## WEST SUSSEX COUNTY COUNCIL CONSULTATION

| <b>LOCATION:</b>                | Land between Ashurst & Badgers Ham Manor Way<br>Angmering BN16 4JQ                                                                                                       |
| <b>SUBJECT:</b>                 | A/31/19/PL<br><br>1 No. two storey house (resubmission following A/87/18/PL). This application is a Departure from the Development Plan & affects a Public Right of Way. |

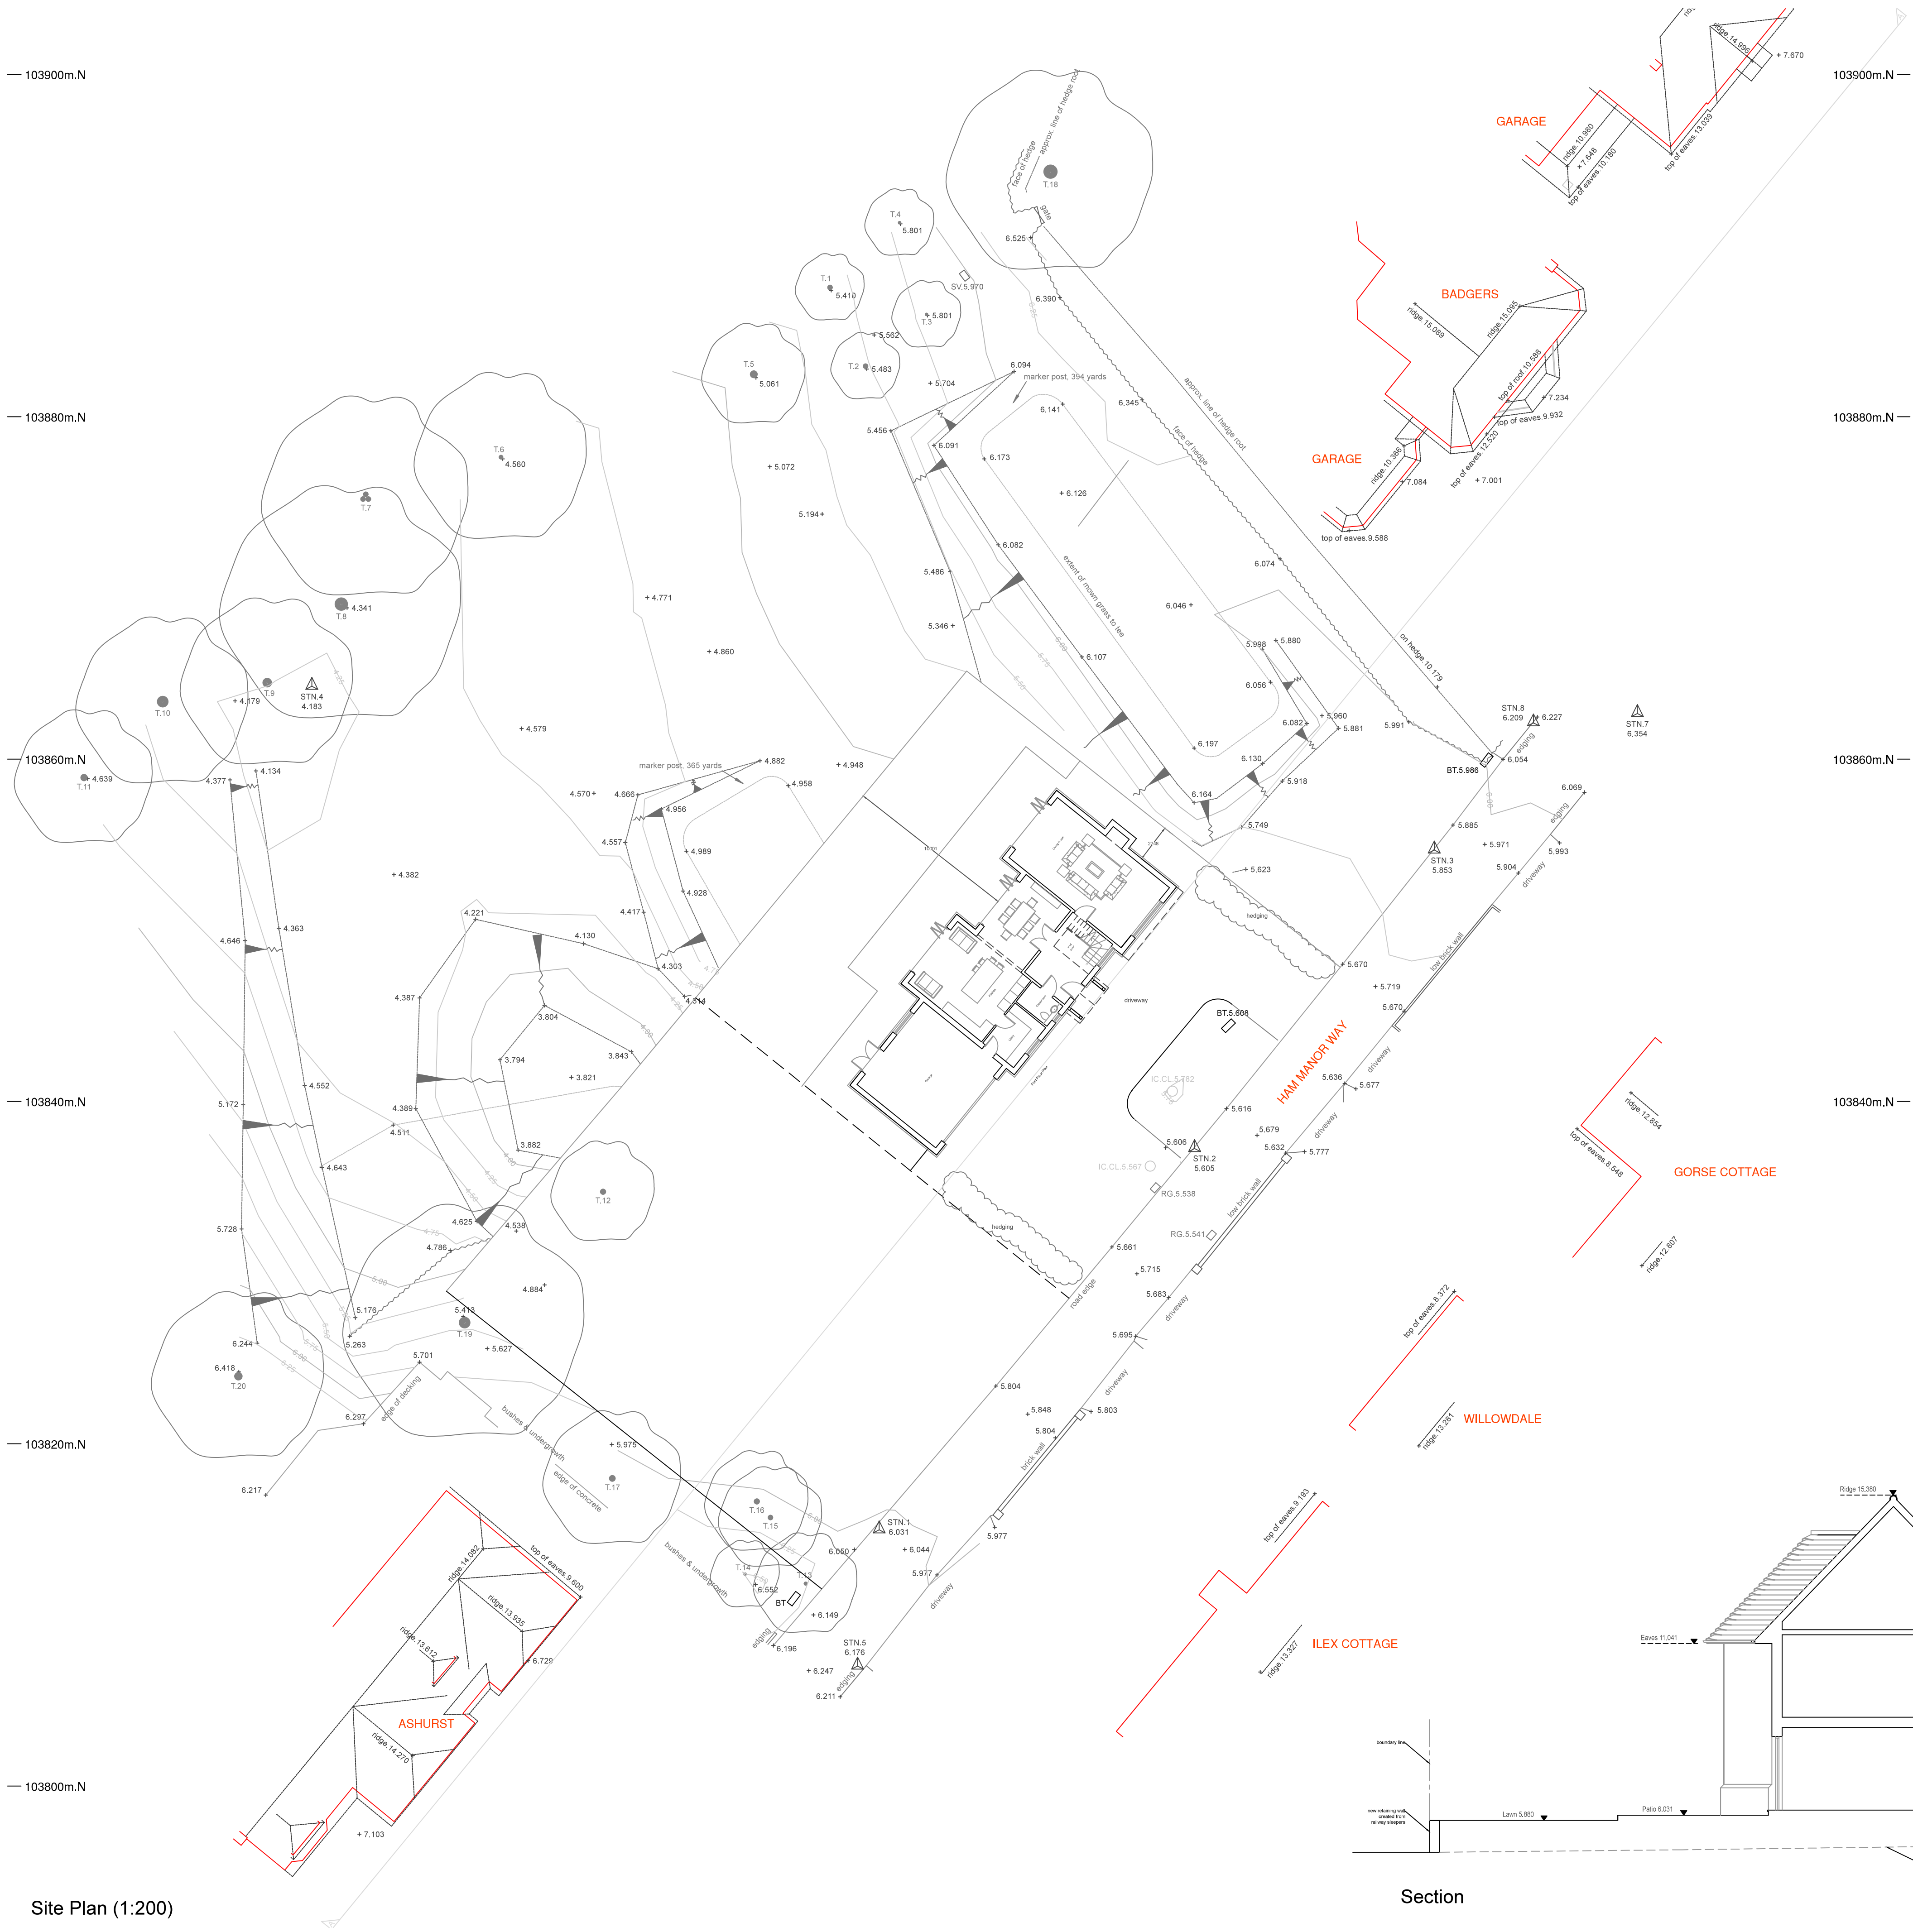
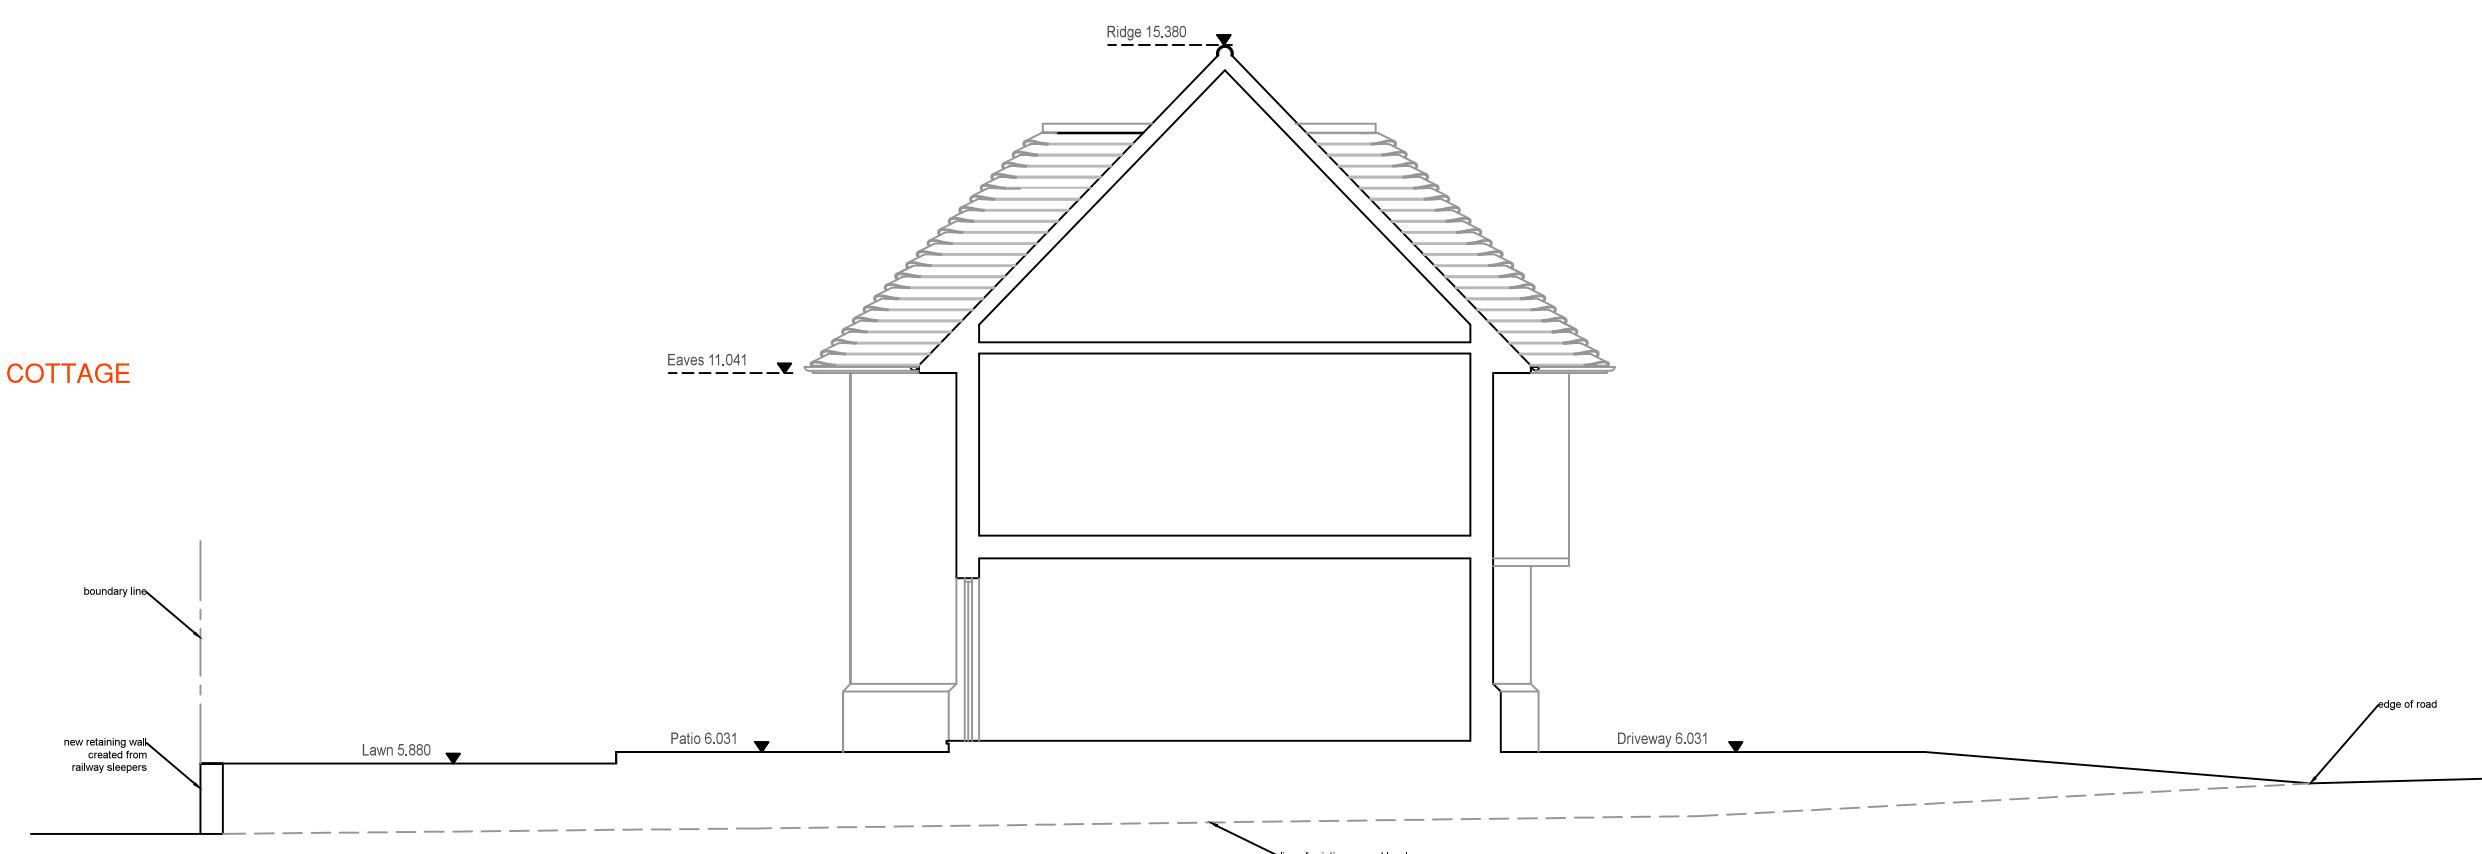
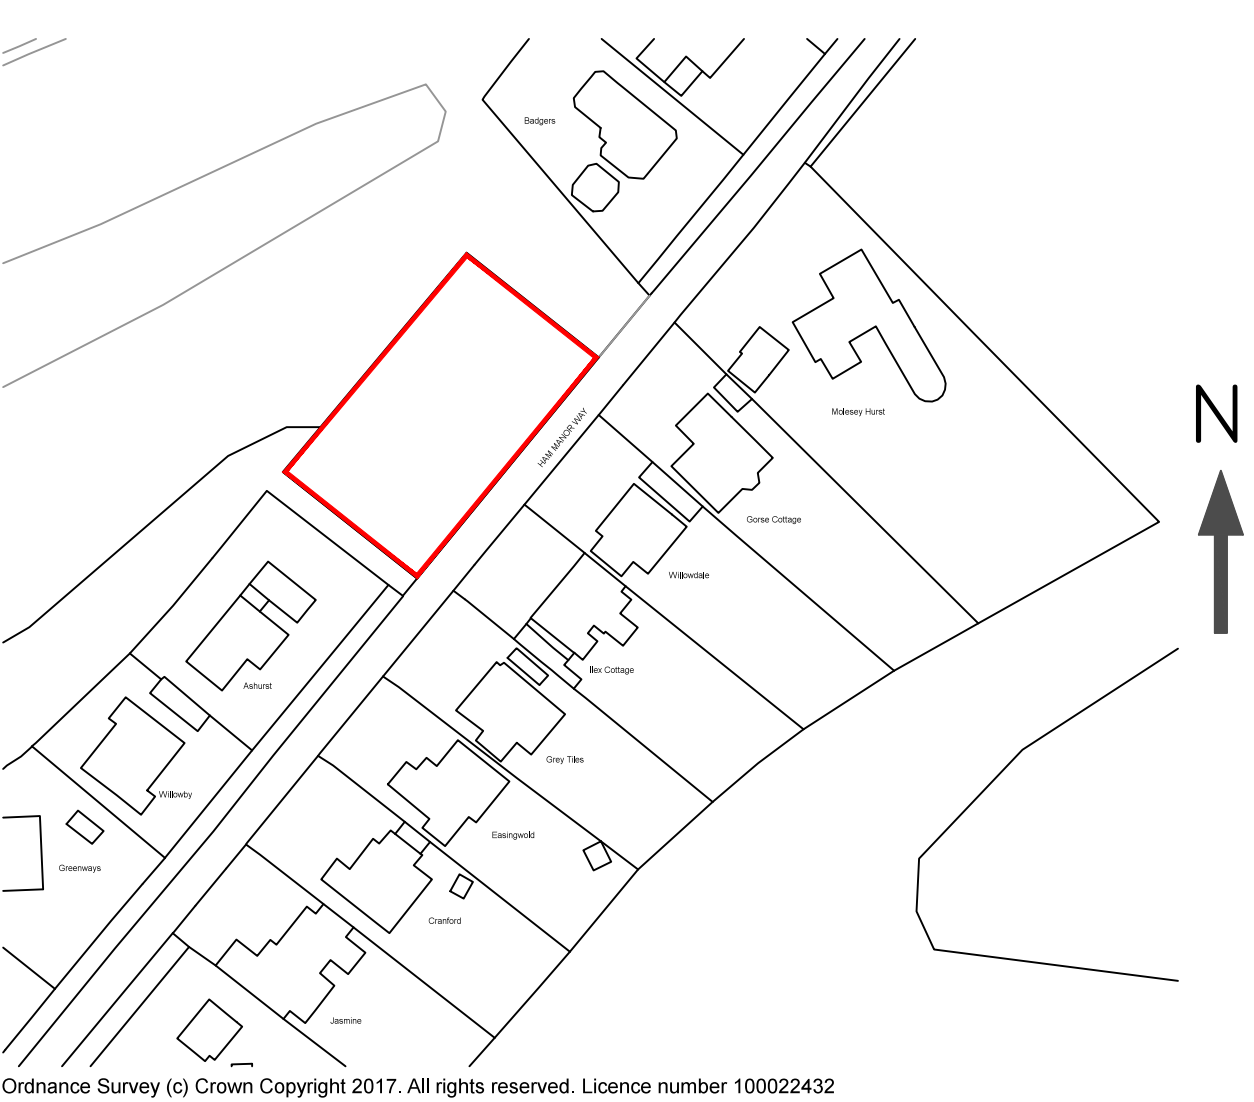
From an inspection of the proposed plans two openings will be created for vehicle access creating an in/out drive. The applicant should gain the permission of the proprietor of the private road to carry out the site access works.

The applicant is advised to contact the proprietor of Ham Manor Way to obtain formal approval to carry out the site access works on the private lane
